**BROADWATER GARDENS
PARKING PLAN - BASEMENT 02**

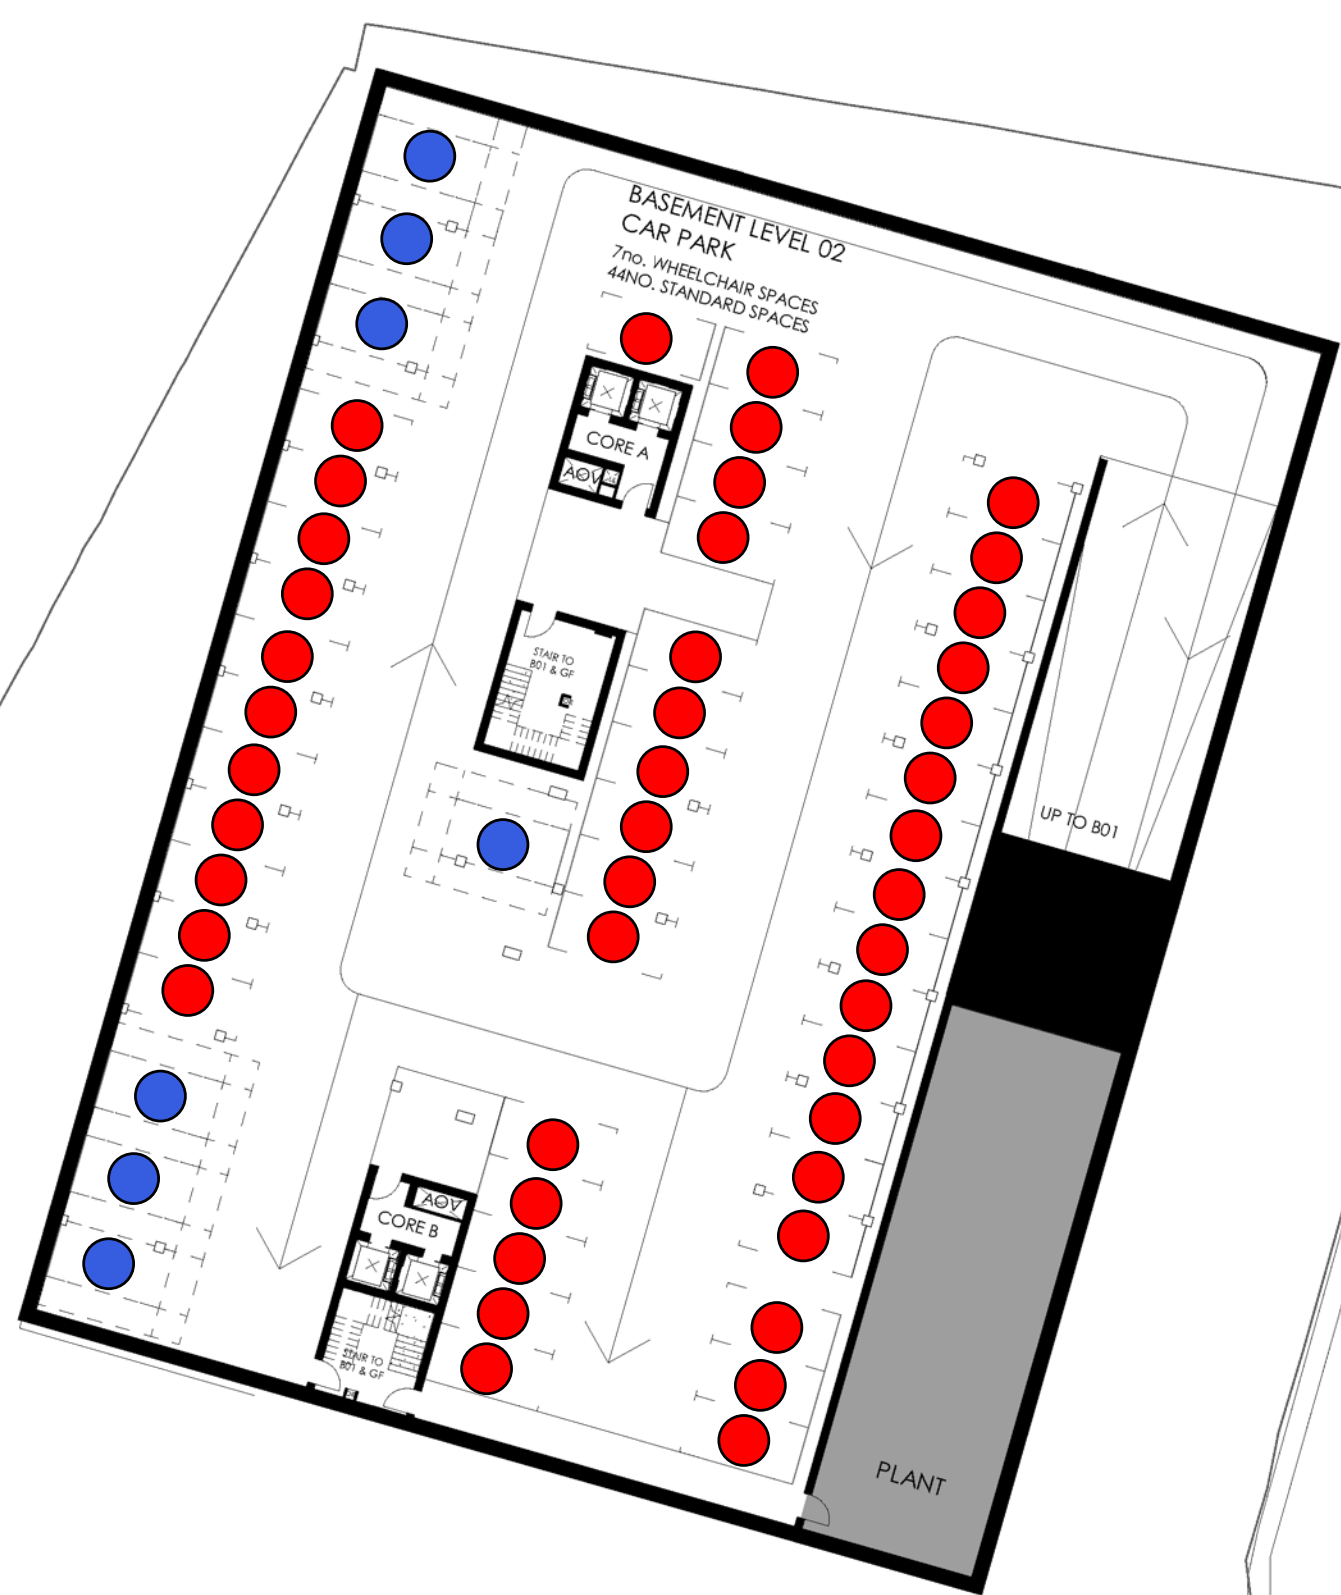
- 1 . Allocated parking space. Current plans only include less than 0.7 parking spaces per household. This is clearly an under estimation of the number of cars that new neighbours would own. In our development we have around 1.3 cars per household. Although we live near the centre and the train people still use the car to move around the county as there are no good connections to neighbouring areas, and not everybody commutes to London for work.

2. Transitioning to net 0 emissions. The current allocated parking only contemplates one or 2 places for electrical vehicles, as we are transitioning towards a greener future this new build should consider adding at least one plugging point per car to be future proof. In our development there are already more than 2 electric cars around.

1 Section A
1 : 100

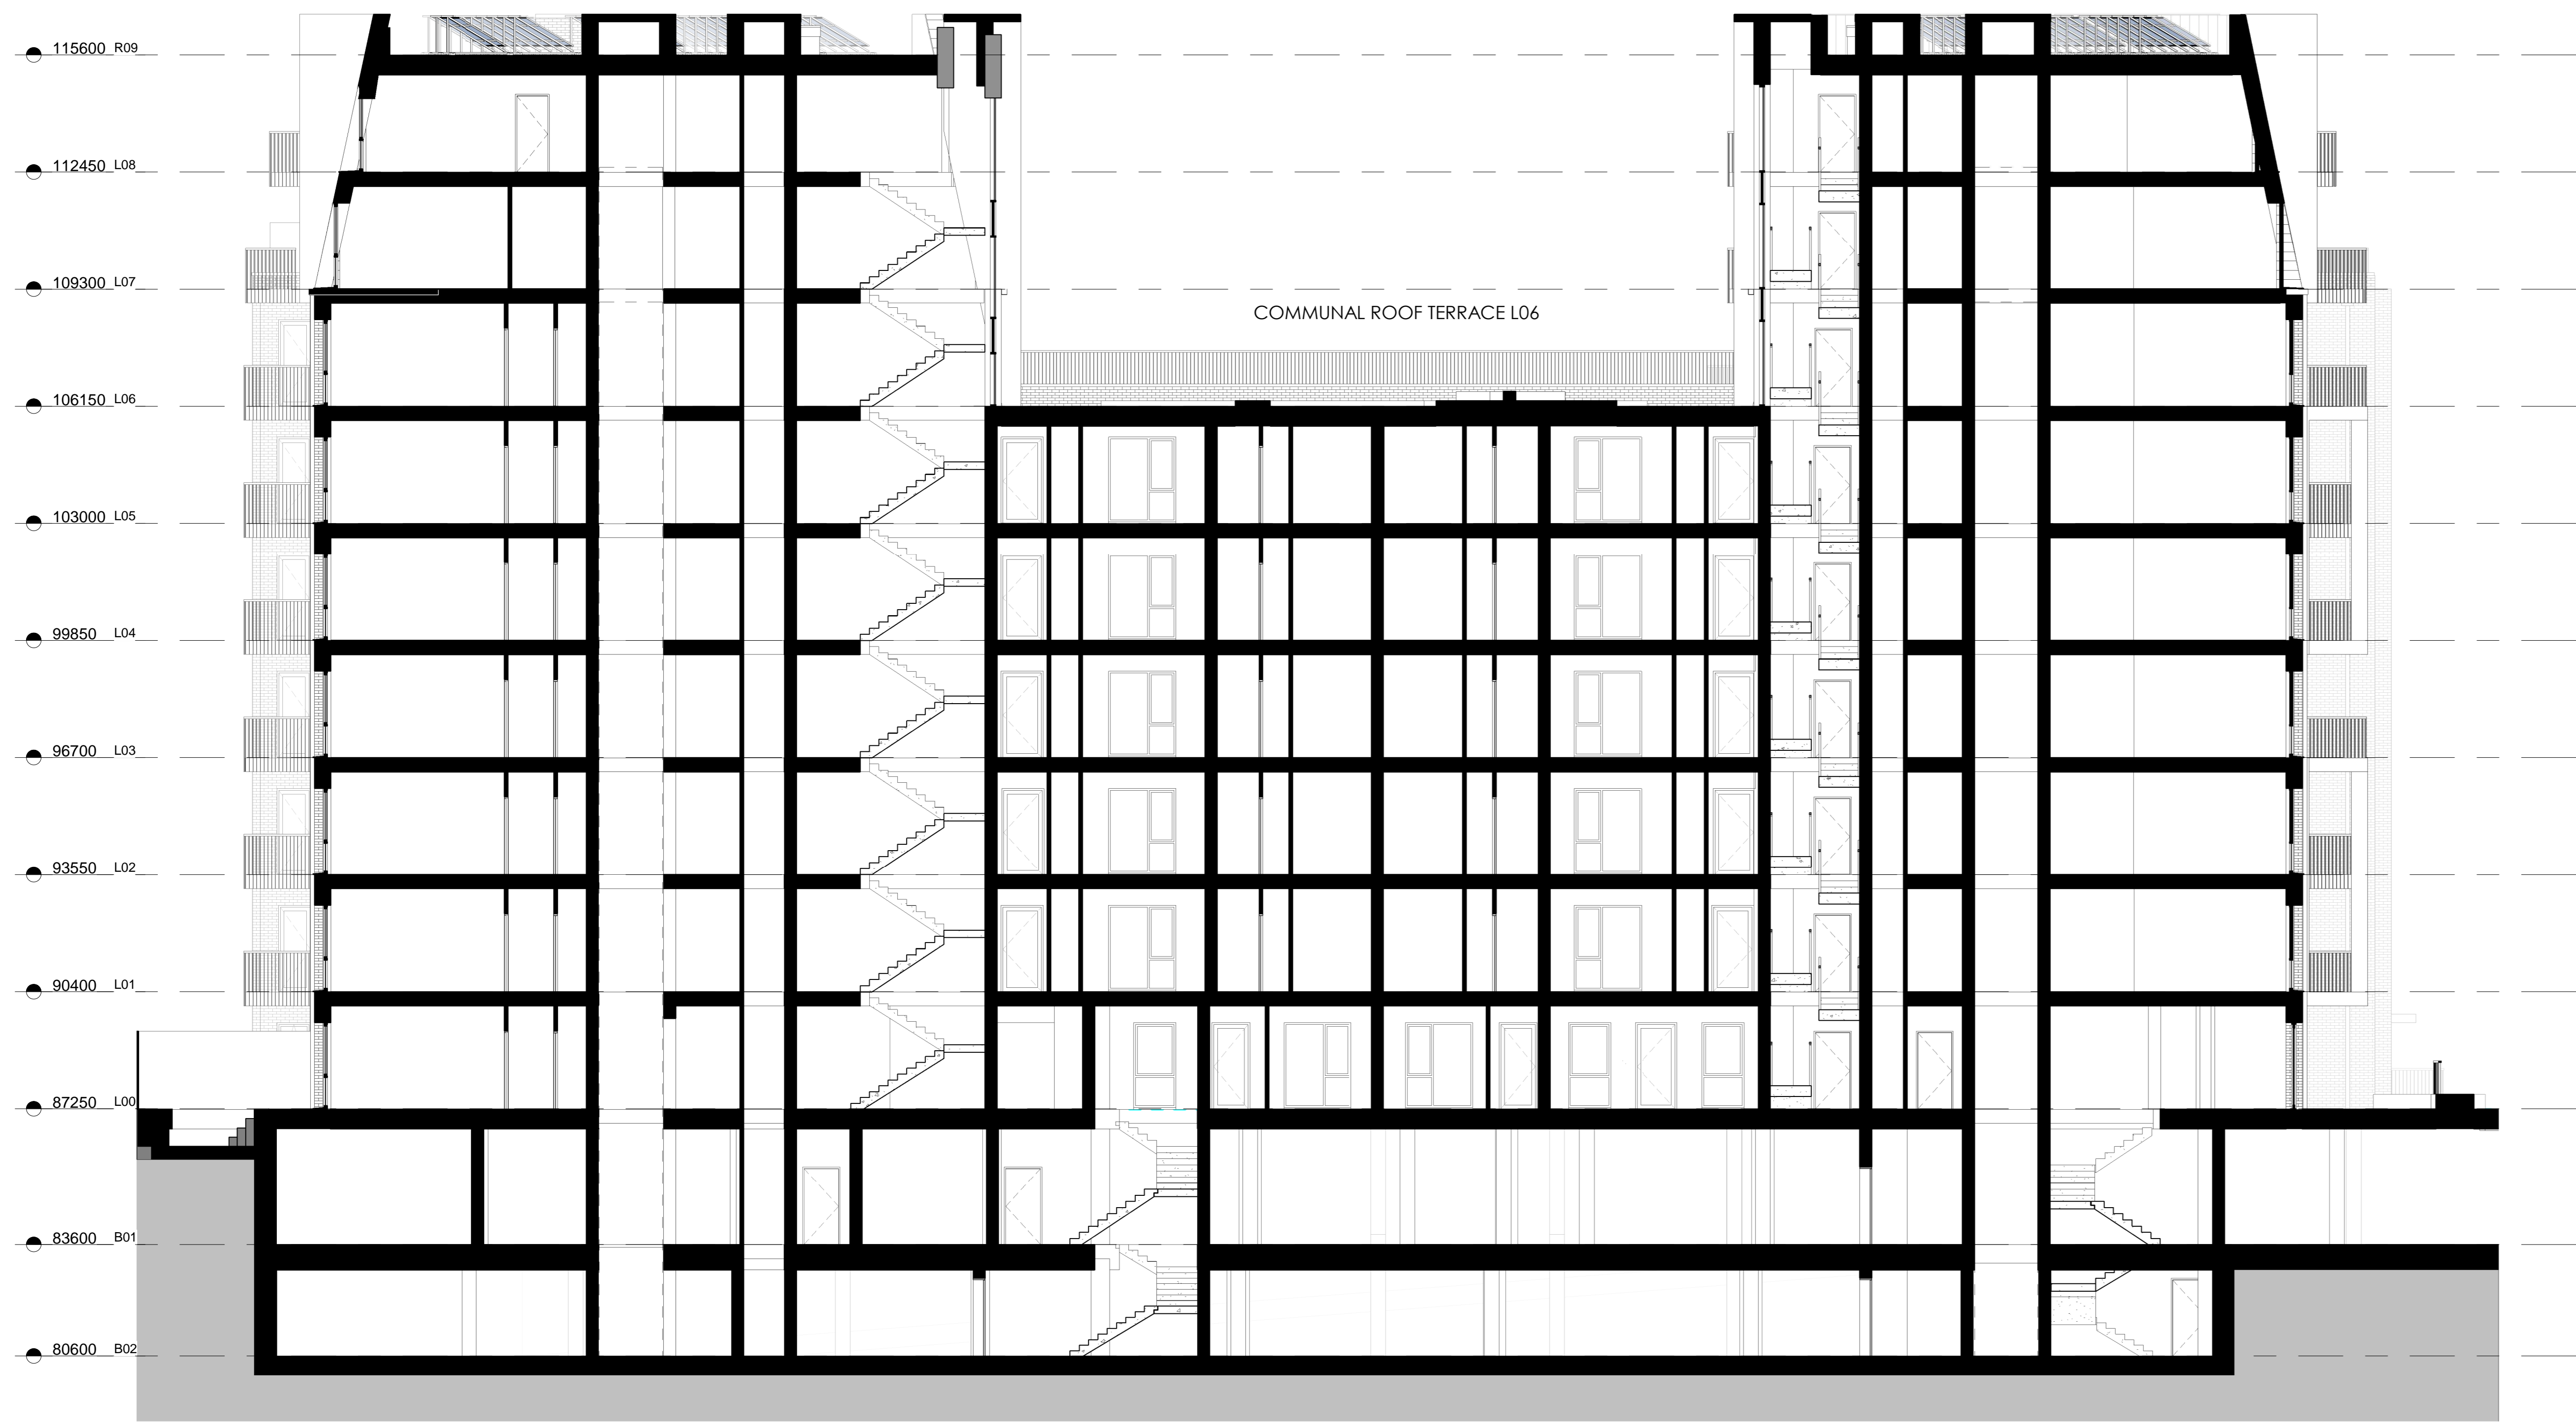
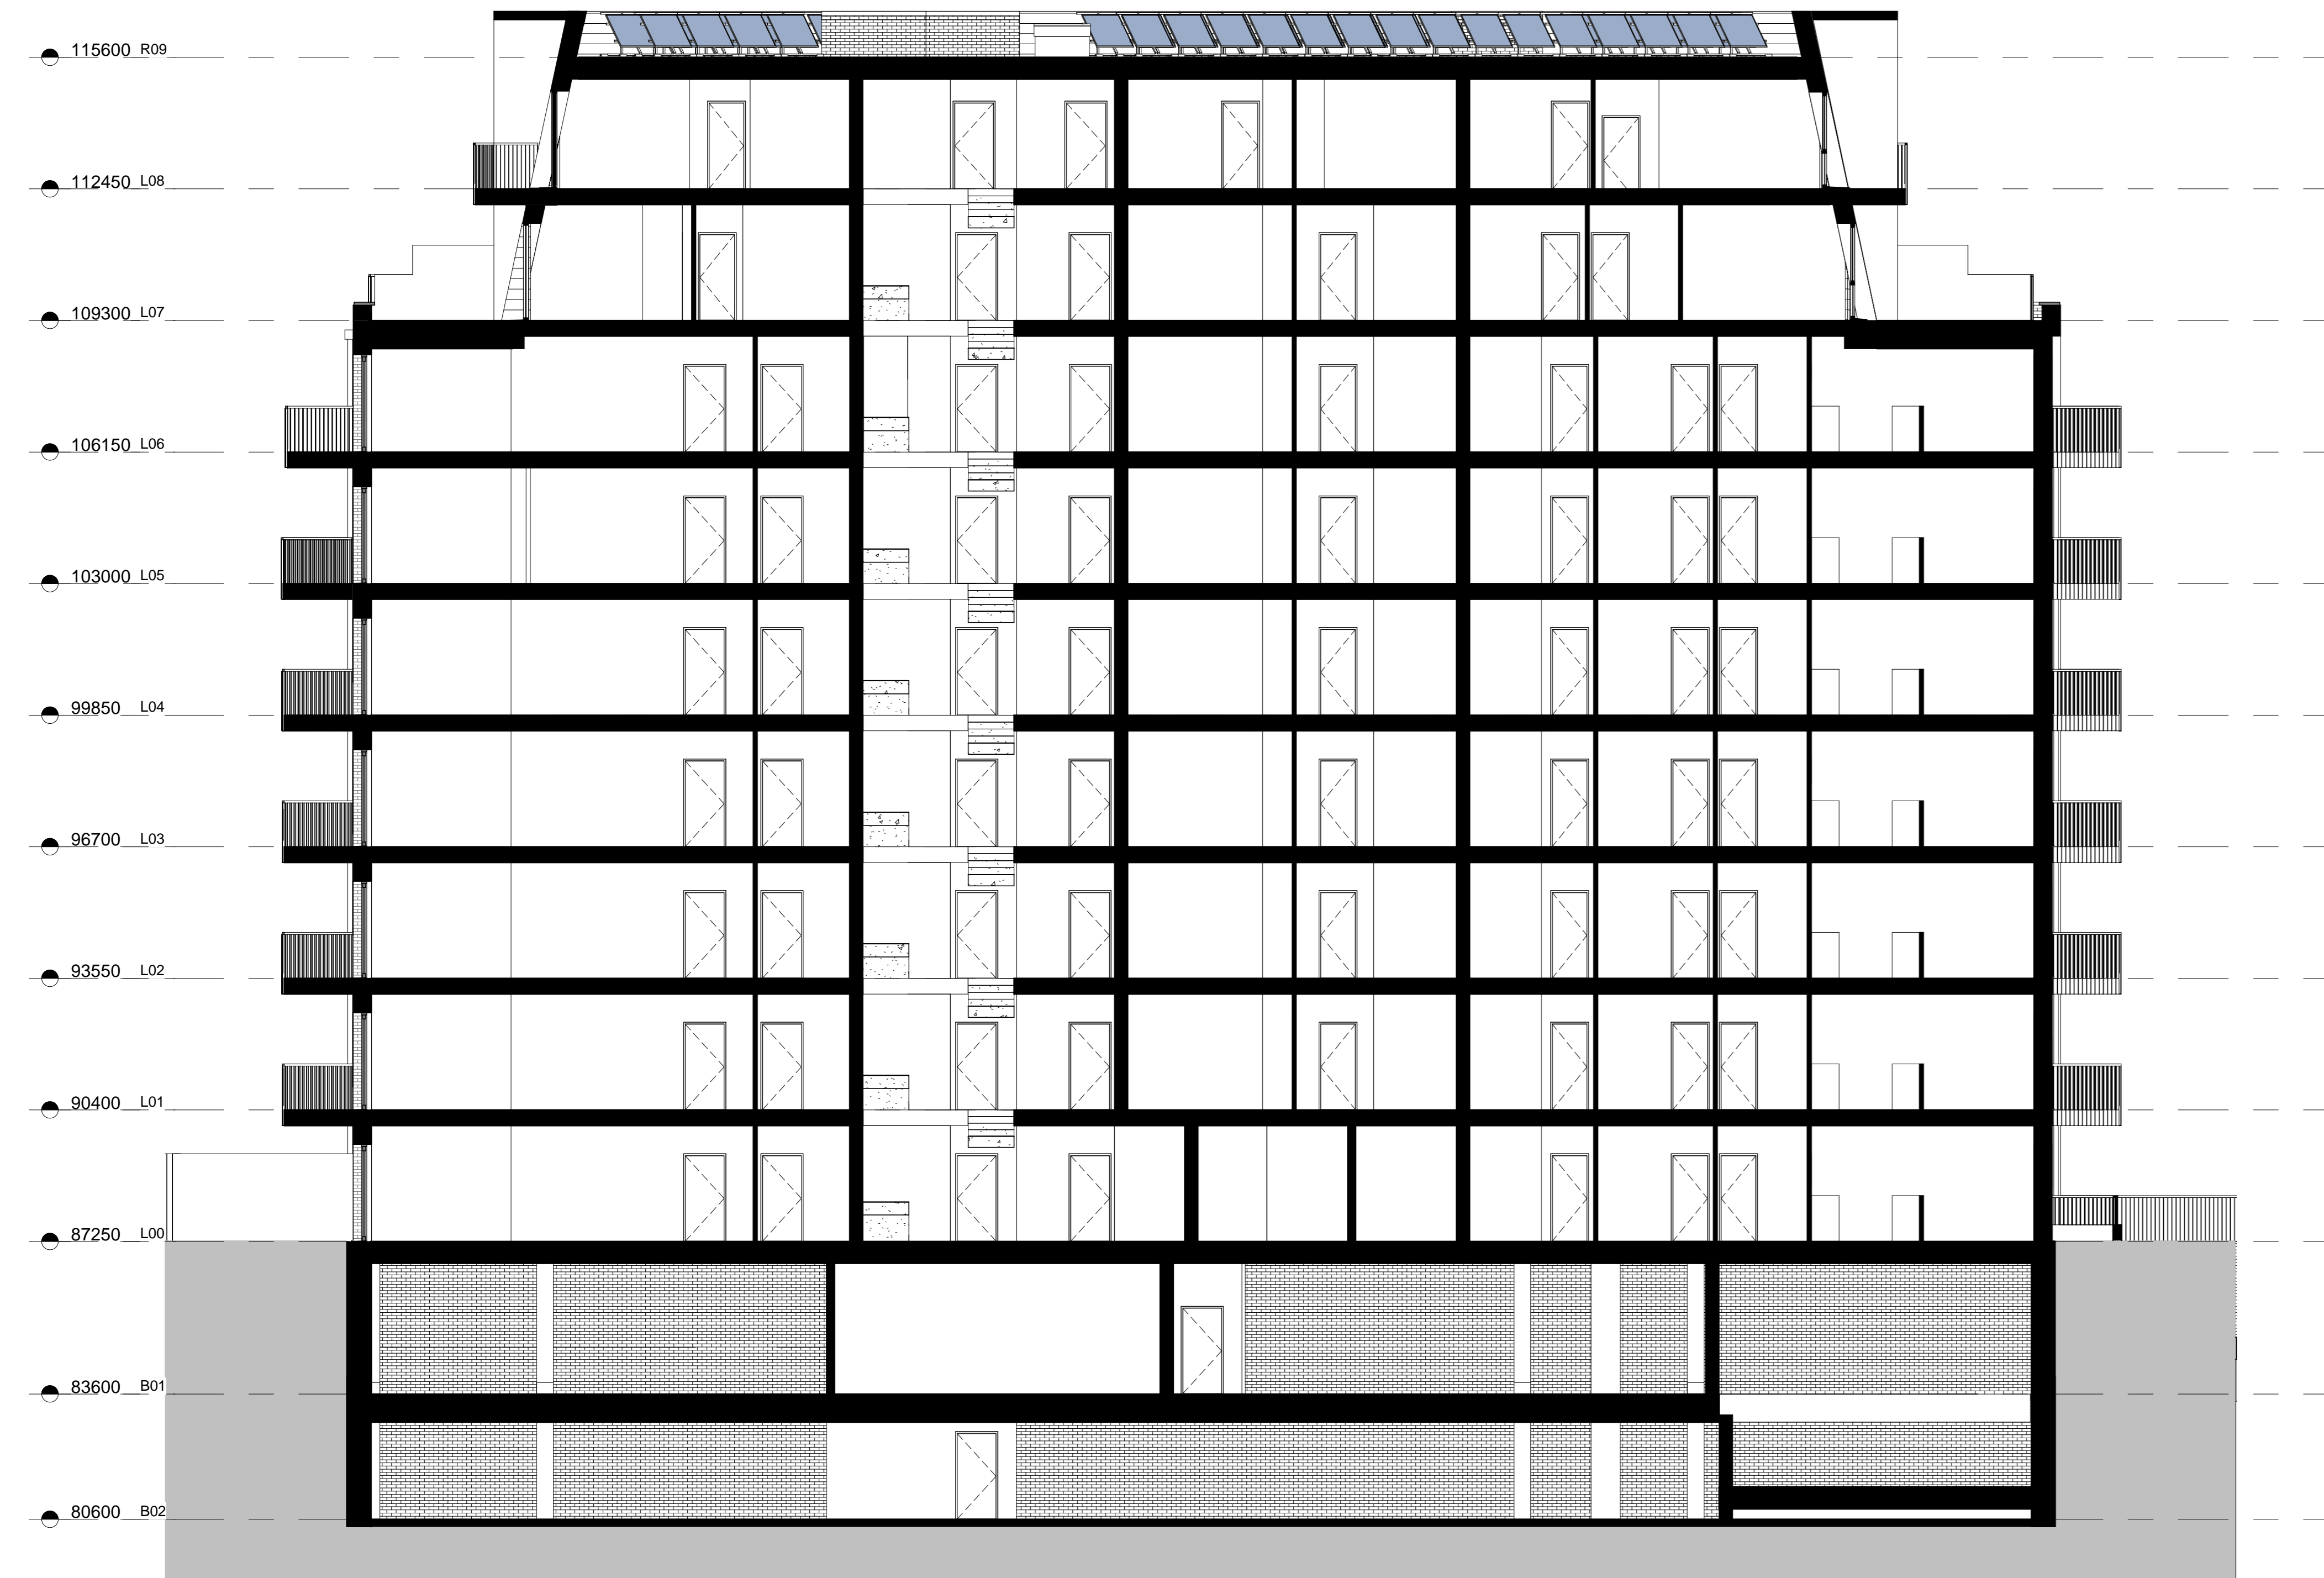
3. We are concern about privacy, the current proposal aims for buildings up to 9 stories that will be facing straight down to our gardens, the biopark was a place of work so no body would be looking out the windows directly into our household.

7. The current proposal has several 9 stories building which is 5 times higher than the buildings around and is almost twice the size of what a garden city construction is supposed to be. Current council policy only allows for buildings over 5 stories under exceptional circumstances.
